Location: Highcroft Painter Wood Whalley Old Road Billington BB7 9JD

Proposal: Approval of details reserved by condition 2 (specifications of external materials and surface water drainage scheme) of planning permission 3/2024/1022 granted on appeal.

APPLICATION NO. 3/2026/0222

PROPOSED DRAINAGE PLAN

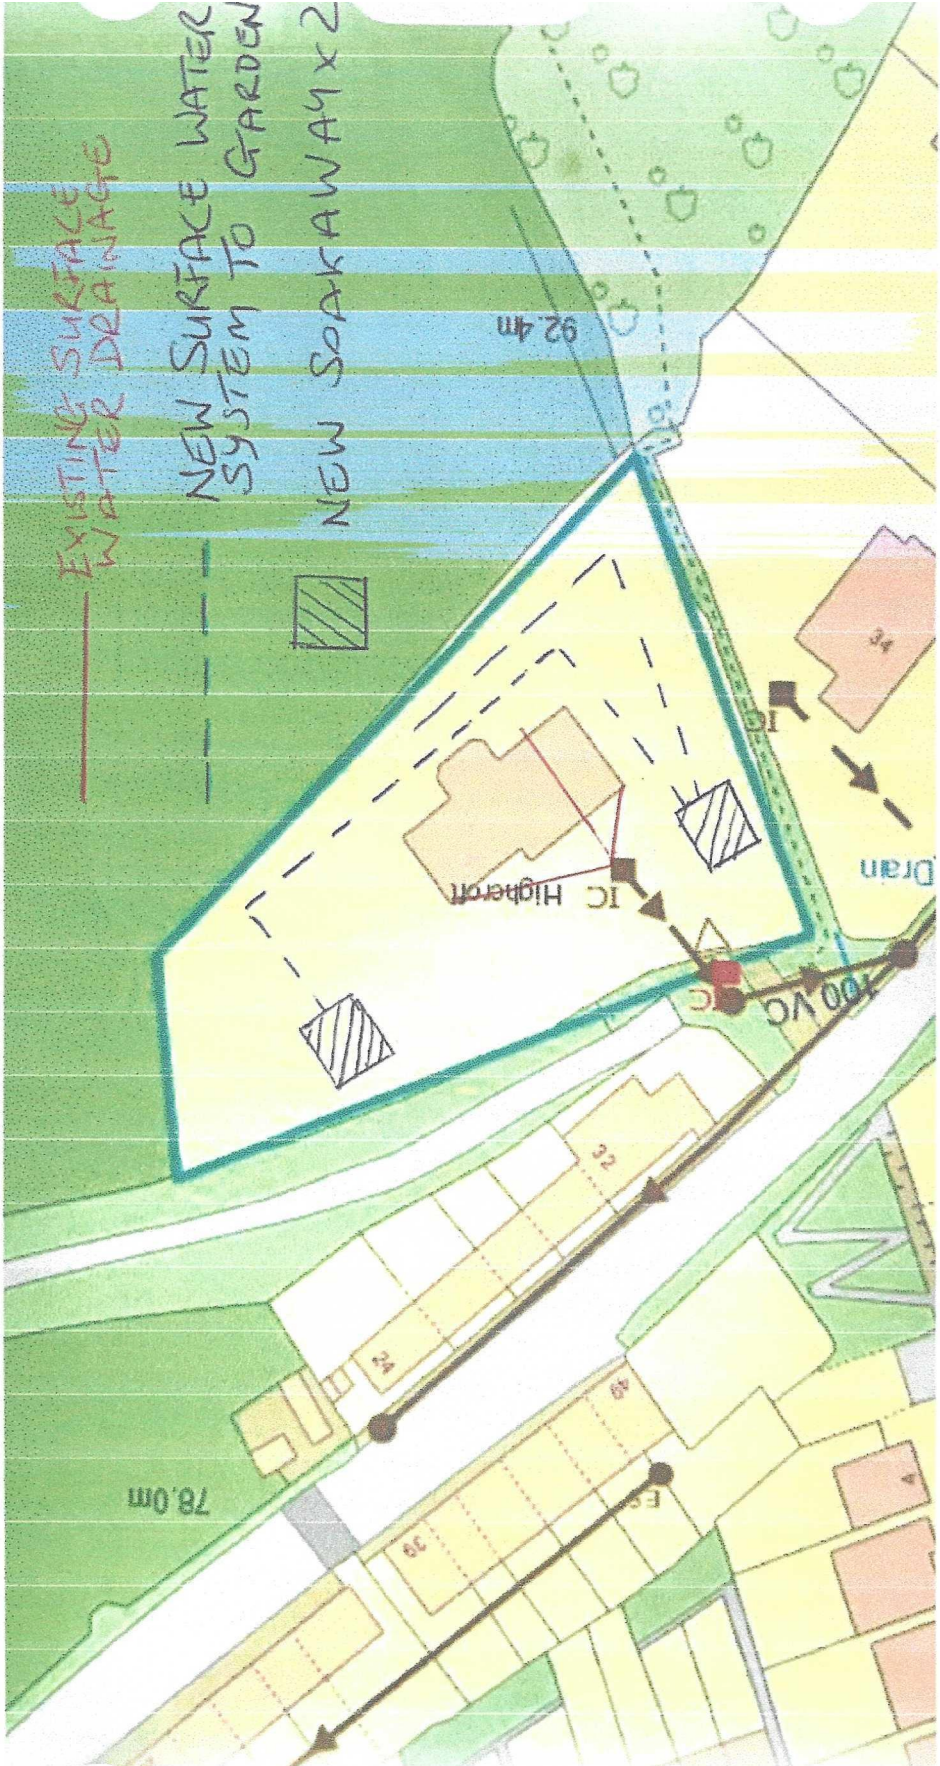
United Utilities were consulted on the documentation and originally objected to the scheme, requesting further details of the gabion basket wall and soakaway position.

The agent for the applicant emailed United Utilities advising them that the application is a householder application, involving the installation of two soakaways which would not link to United Utilities surface water drainage infrastructure.

United Utilities have now removed their objection to the scheme as the existing drainage would remain the same and ground water is to be dealt with within the development. They are satisfied that there would be no interaction with the sewerage system.

As such, Condition 2 (b) is partially discharged insofar that the development is required to be implemented in accordance with the approved scheme and retained.
